**Cover Letter to Submission - State Significant Development (SSD-81767963)
Mixed Use Development 17-24 Loftus Crescent Homebush (SSD2025.2009)**

Strathfield Council Draft Submission to State Significant Development (SSD-81767963) Mixed Use Development 17-24 Loftus Crescent Homebush (SSD2025.2009) – 4 February 2026

Source: DKO, Project No. 13863, Drawing No. DA202, Rev B, Oct2025 – Ground Floor Plan

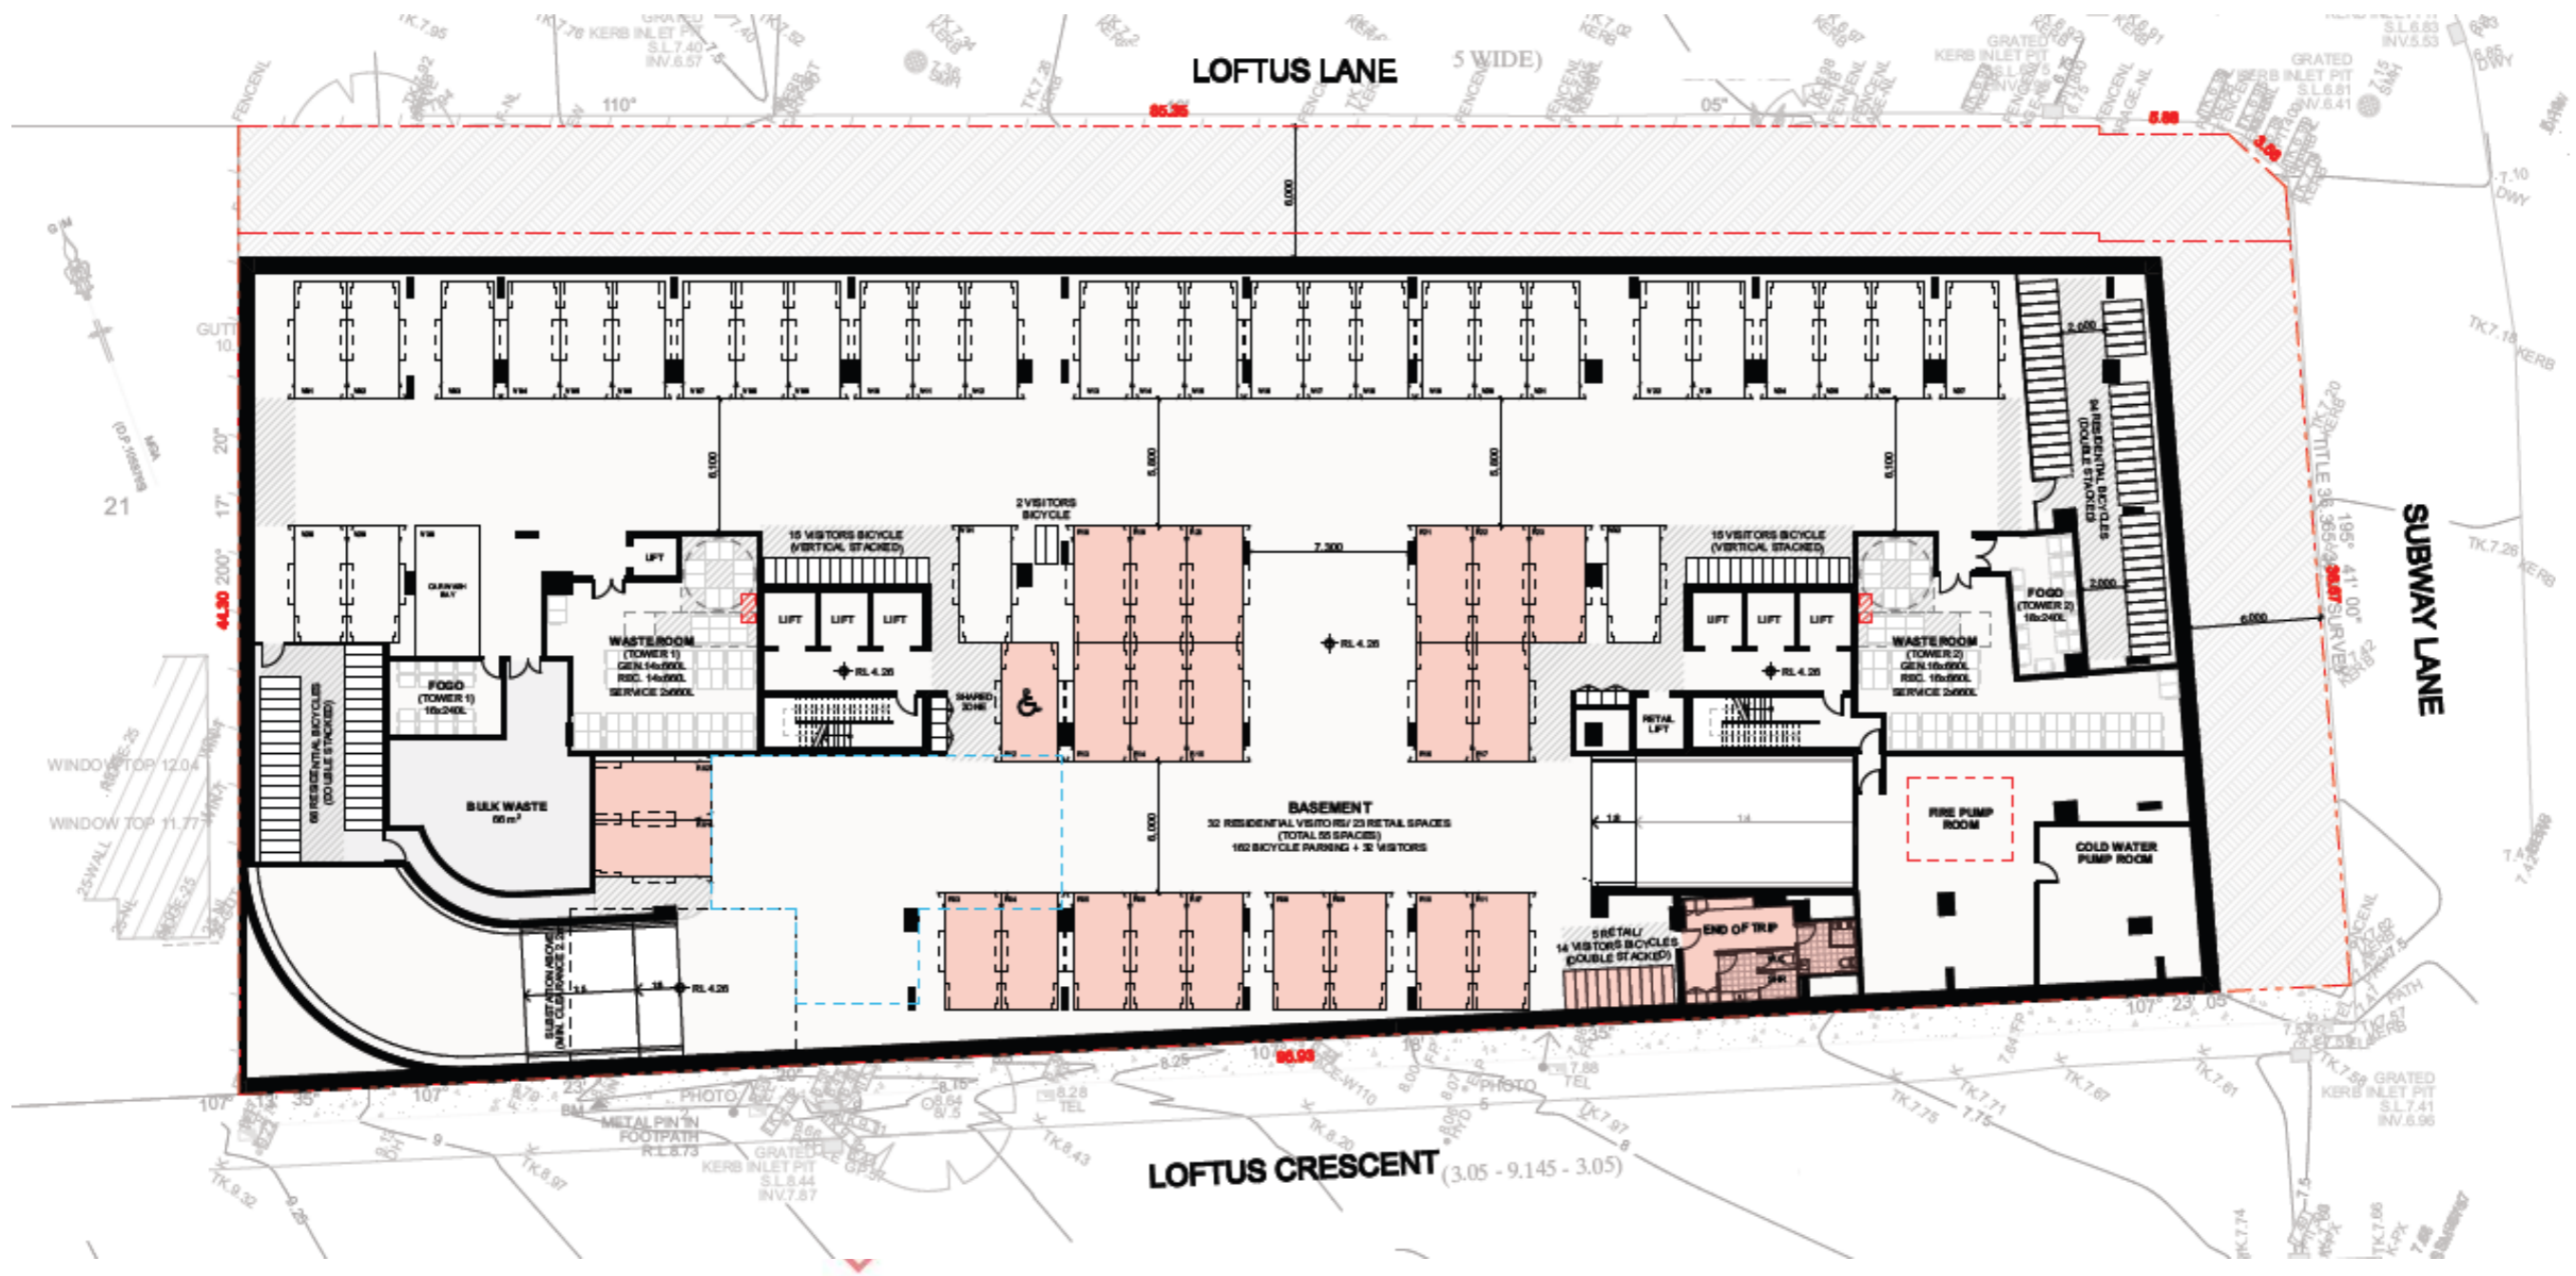
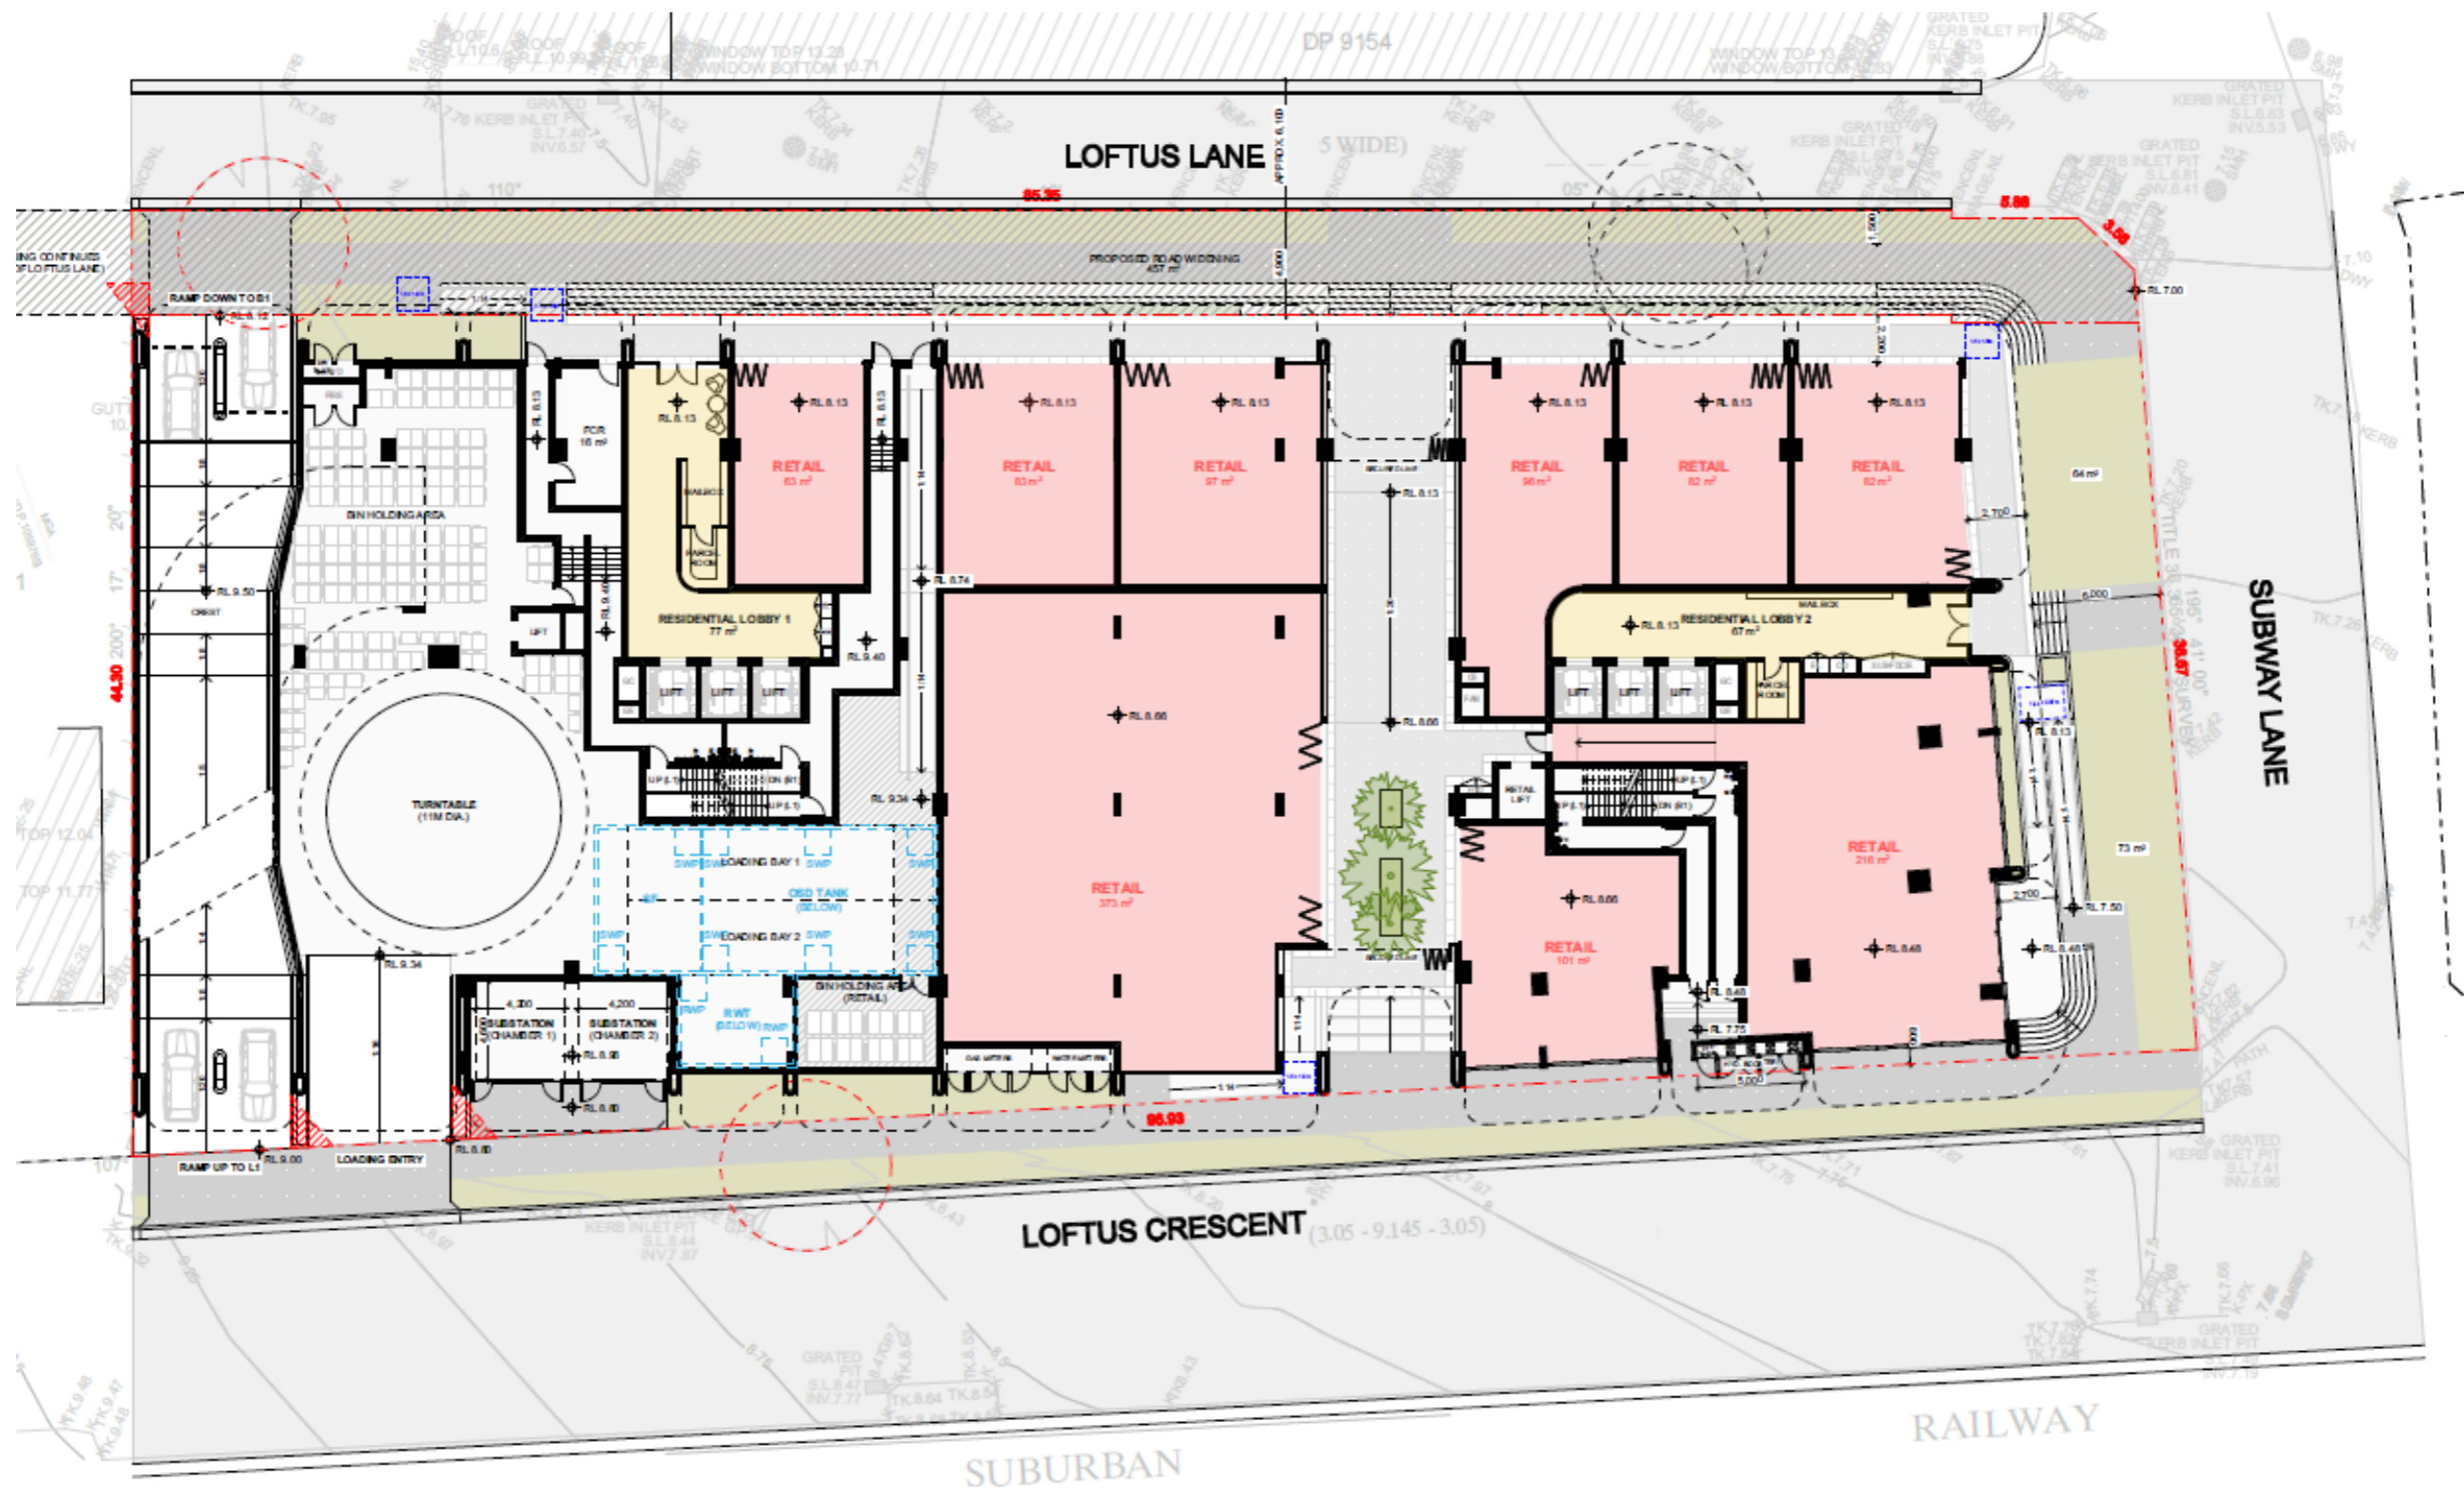
- Space adequate for OSD tank is questioned since it is shown dashed on the Ground Floor Plan and is not shown correspondingly on the Basement 1 Floor Plan. The floor-to-floor heights on the Ground floor are generous and could more easily accommodate the tanks. Alternatively, due to the surplus provision of car parking spaces OSD and water re-use tanks could be located within parking spaces.
